Project 7179  
5 May 2026

**Attention: Lane Cove West Responsible Planning Group**

**12 MARS RD LANE COVE WEST – PROPOSED DATA CENTRE**  
**NOISE EMISSION ASSESSMENT – EXPERT PEER REVIEW**

1 EAST ELEVATION
1 : 500

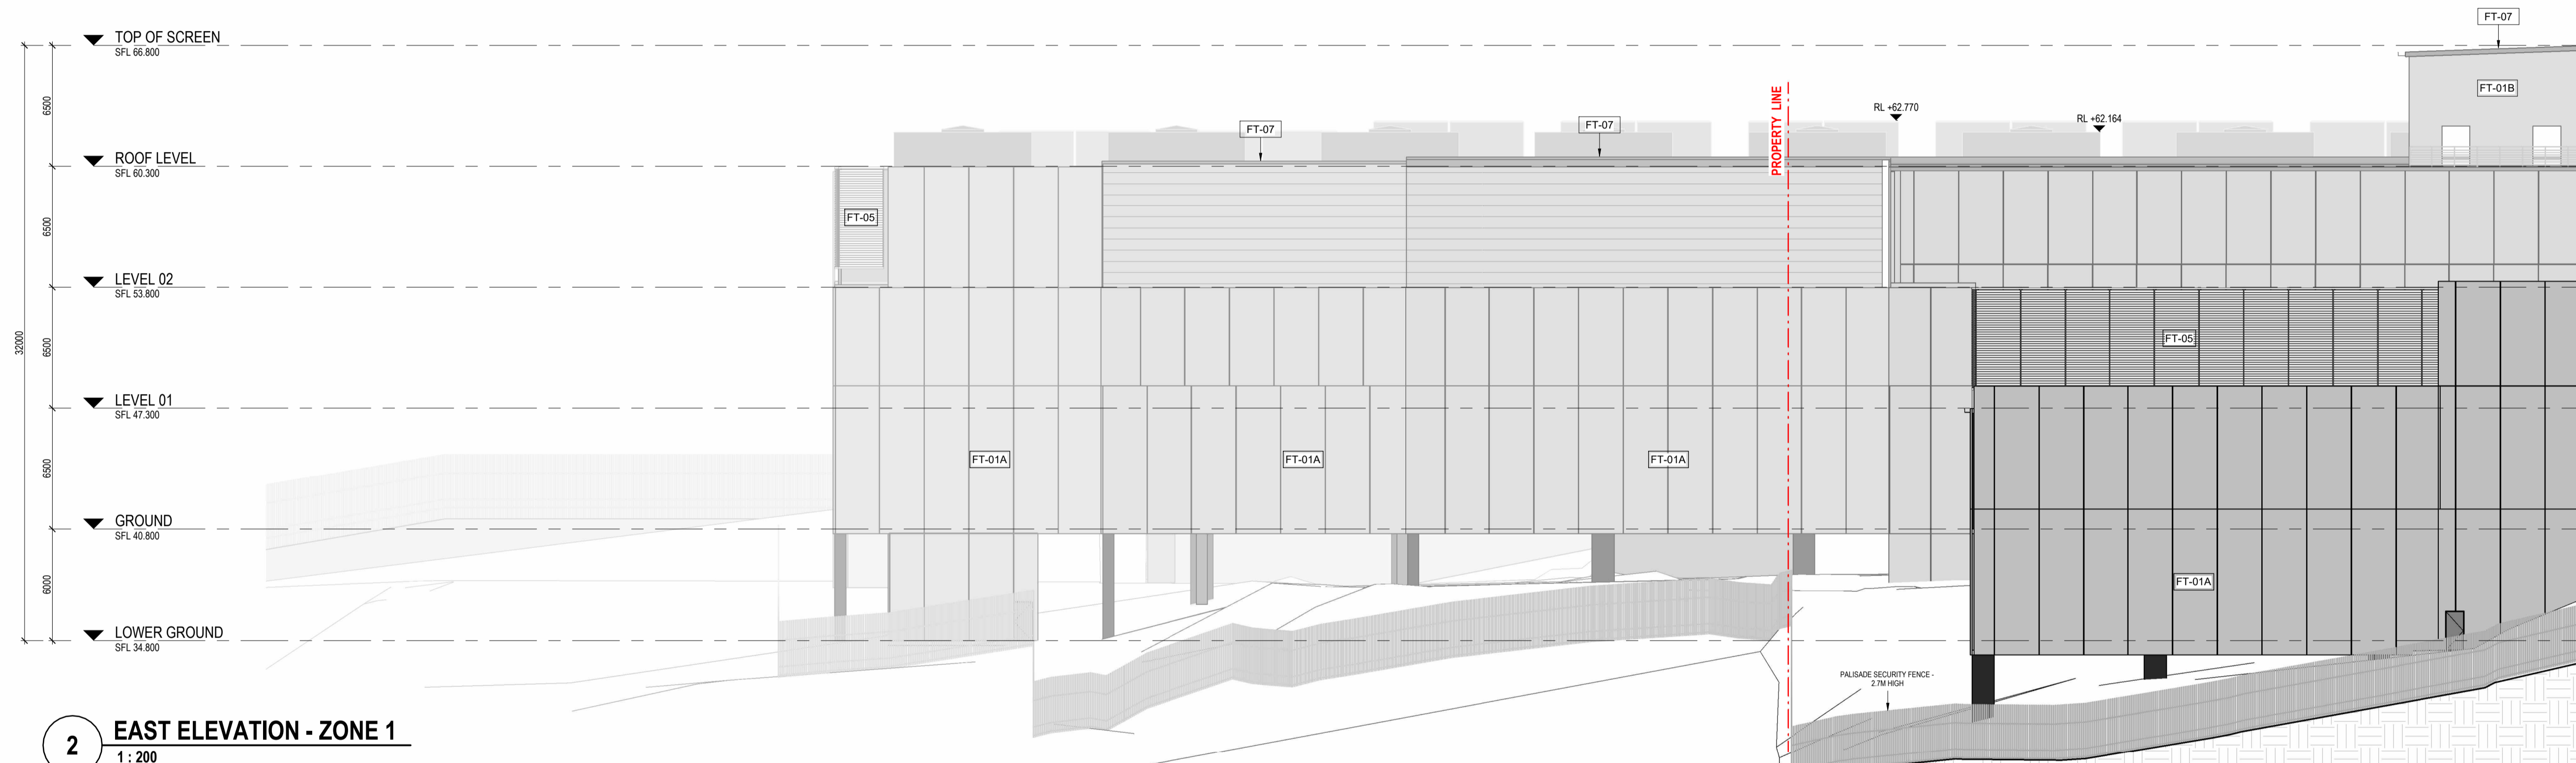
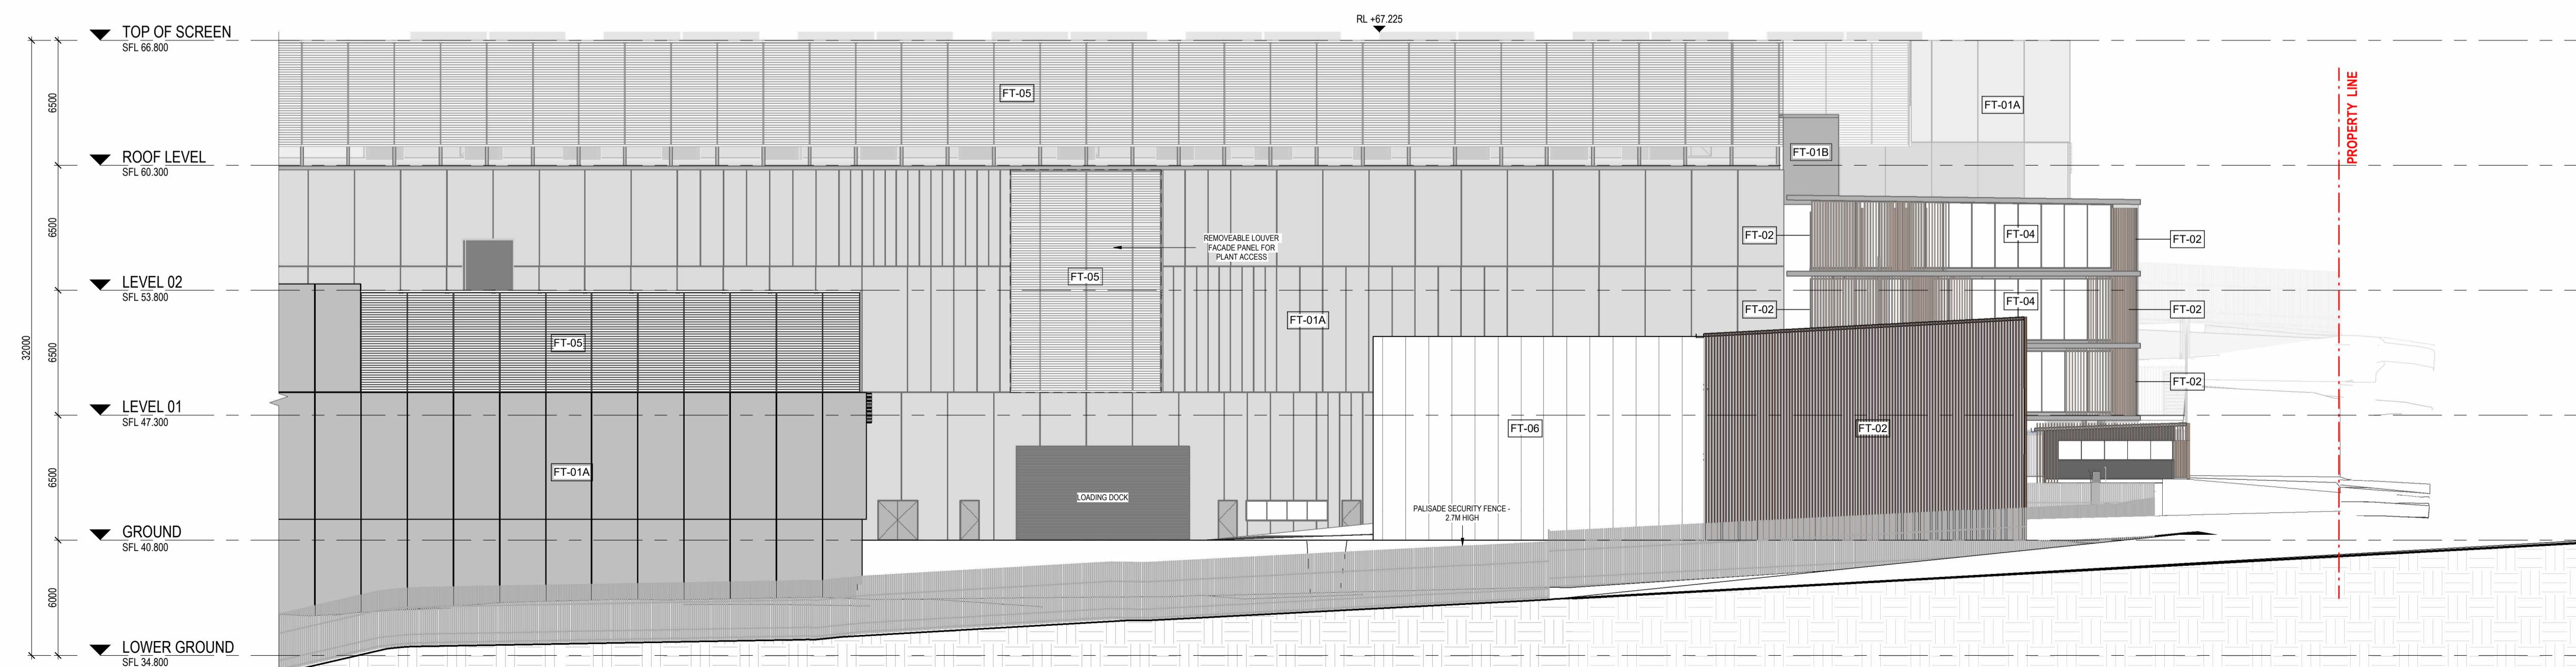
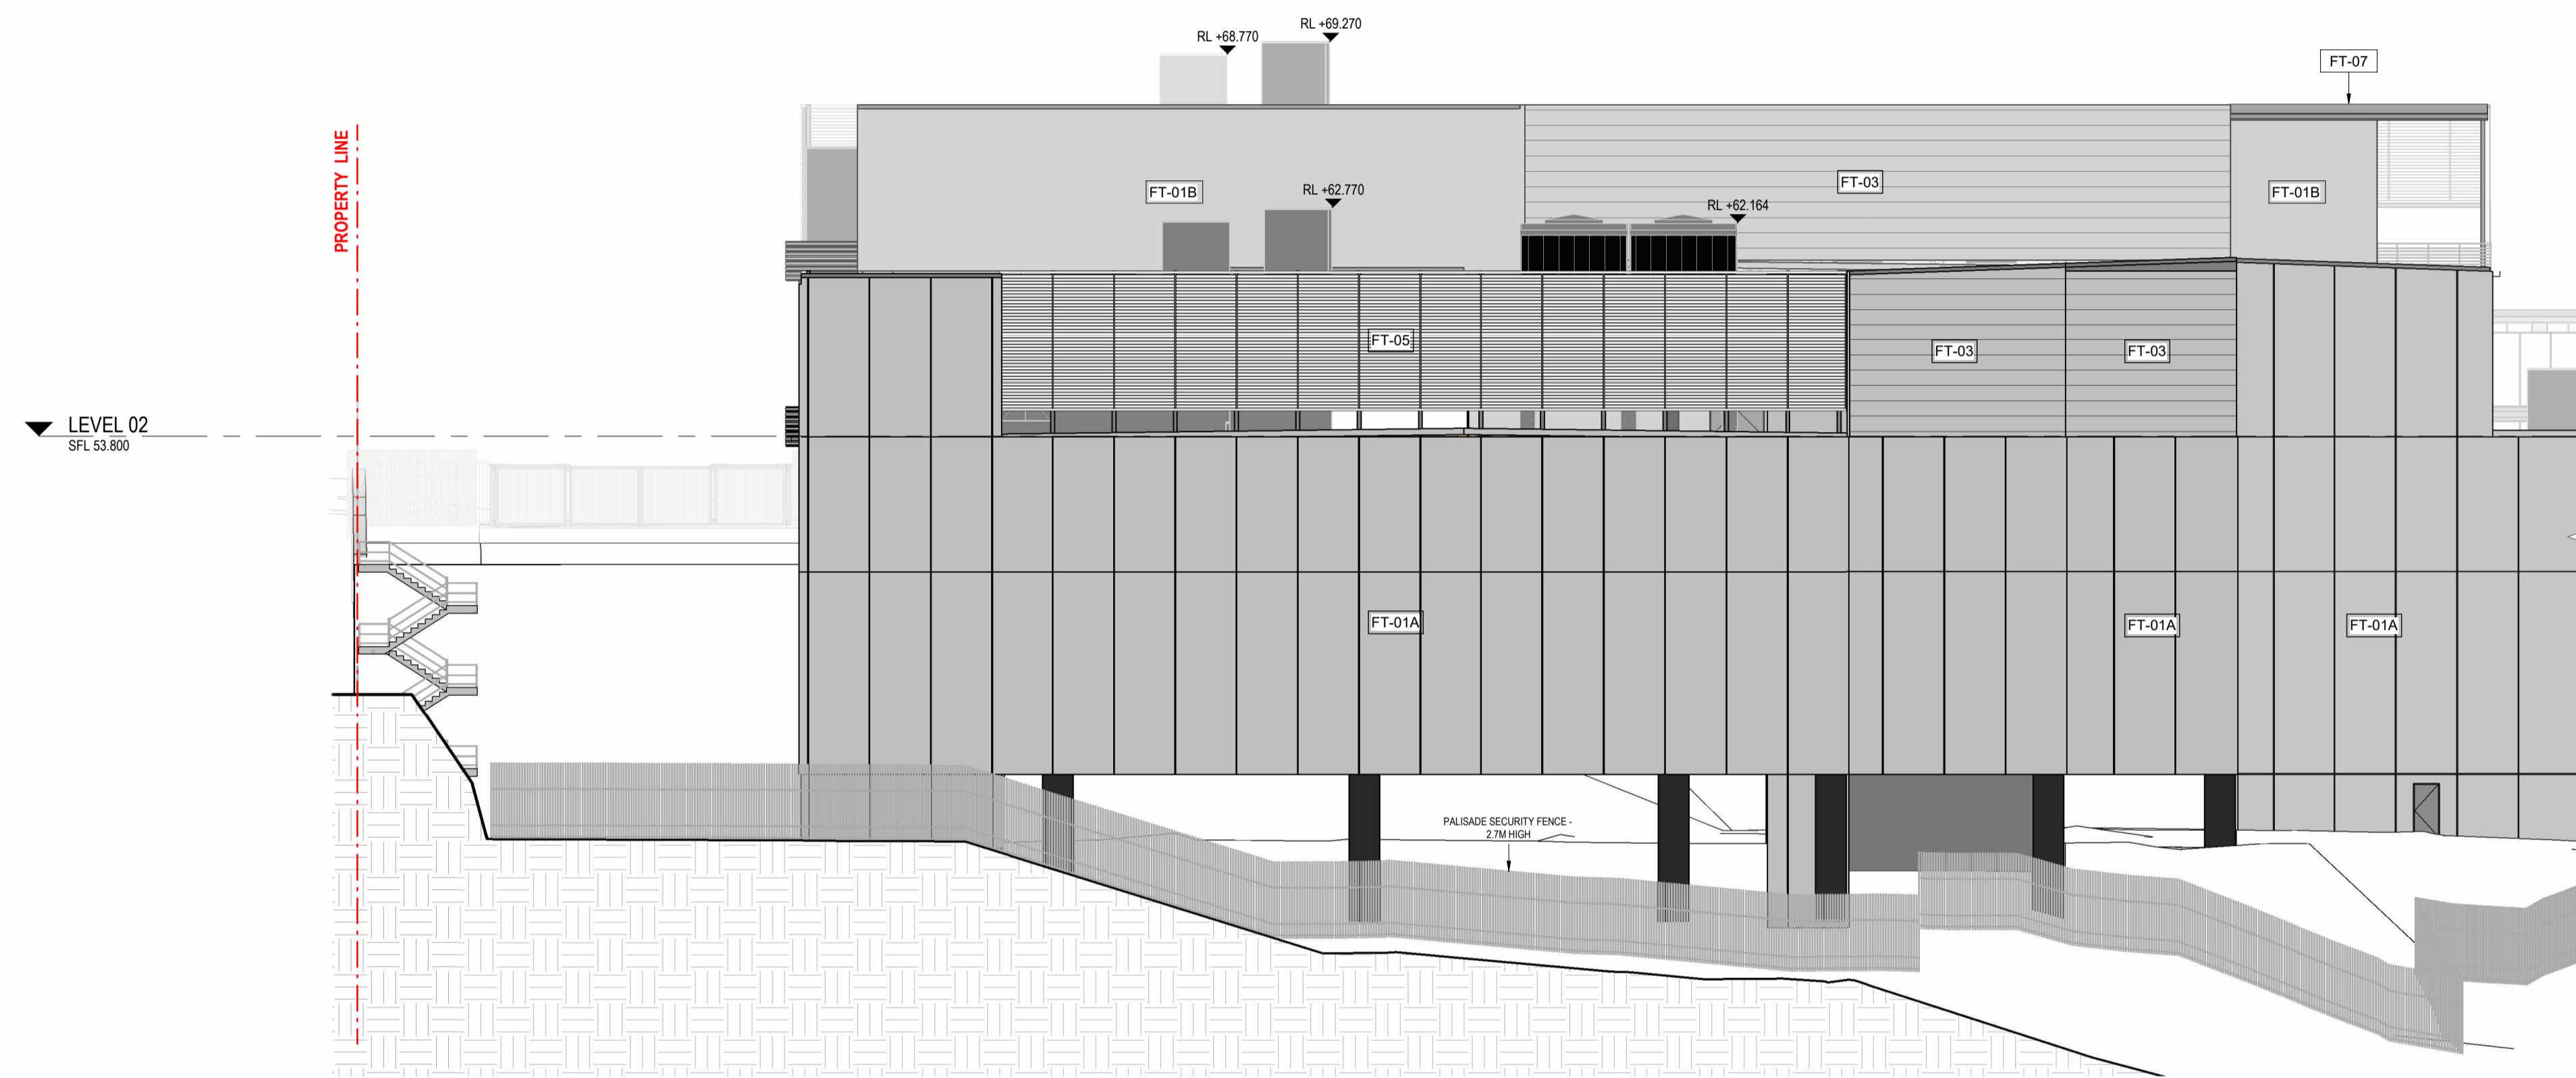
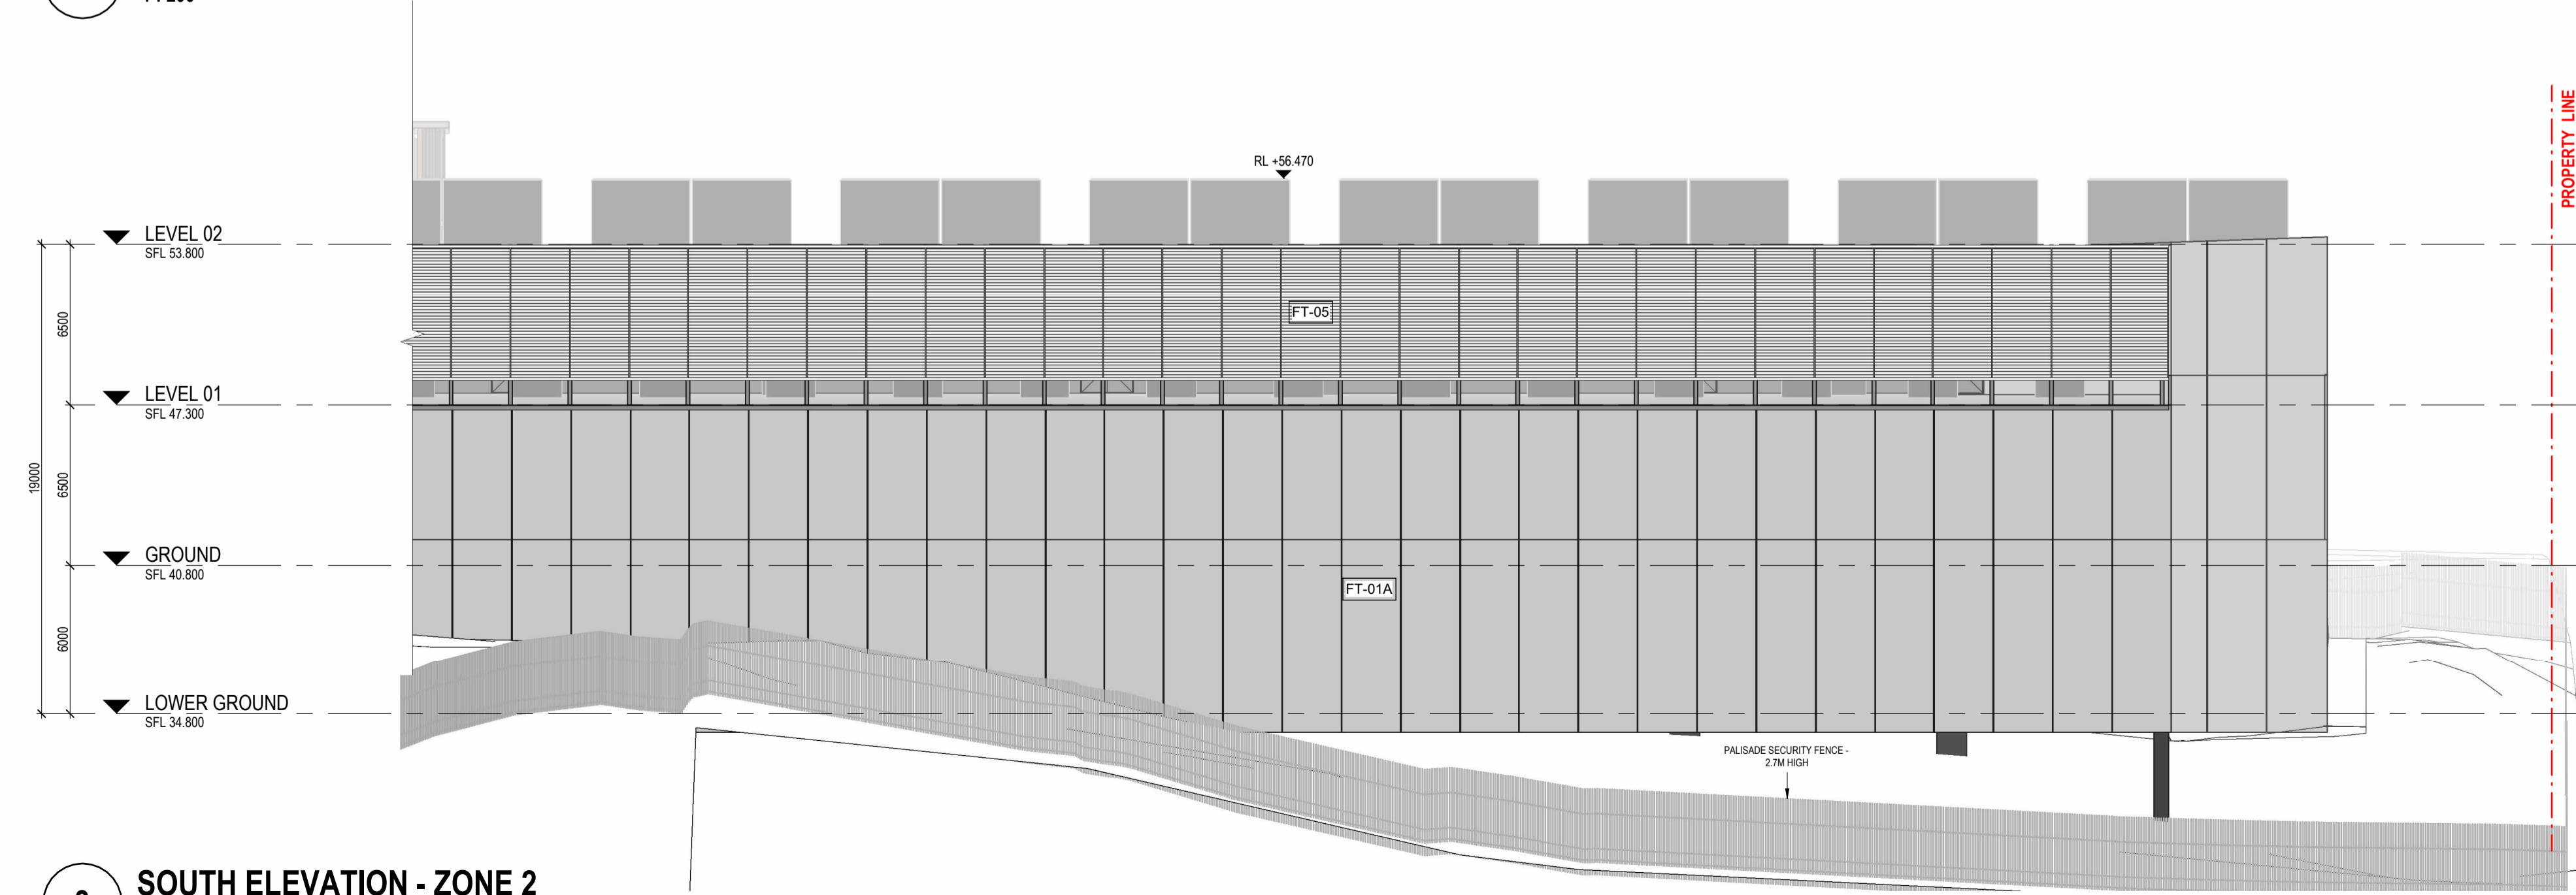
40. Our review of the proposed architectural plans found that the data halls are largely proposed to be constructed with glazed facades, and therefore less able to reduce noise transmission from internal areas externally.

41. To ensure a conservative assessment has been conducted, it is our opinion that internal noise levels for the data halls should be modelled and assessed. In lieu of product specific data, we would consider a nominal internal noise level to be appropriate for an initial assessment as conducted by SLR.

42. This assumed internal noise level would need to be conservatively high to ensure any necessary recommendations can be accounted for. Such recommendations would include internal acoustic treatment to the data halls, such as absorptive wall linings to reduce reverberation, or increased glazing thickness for façade windows to adequately control breakout noise through the façade.
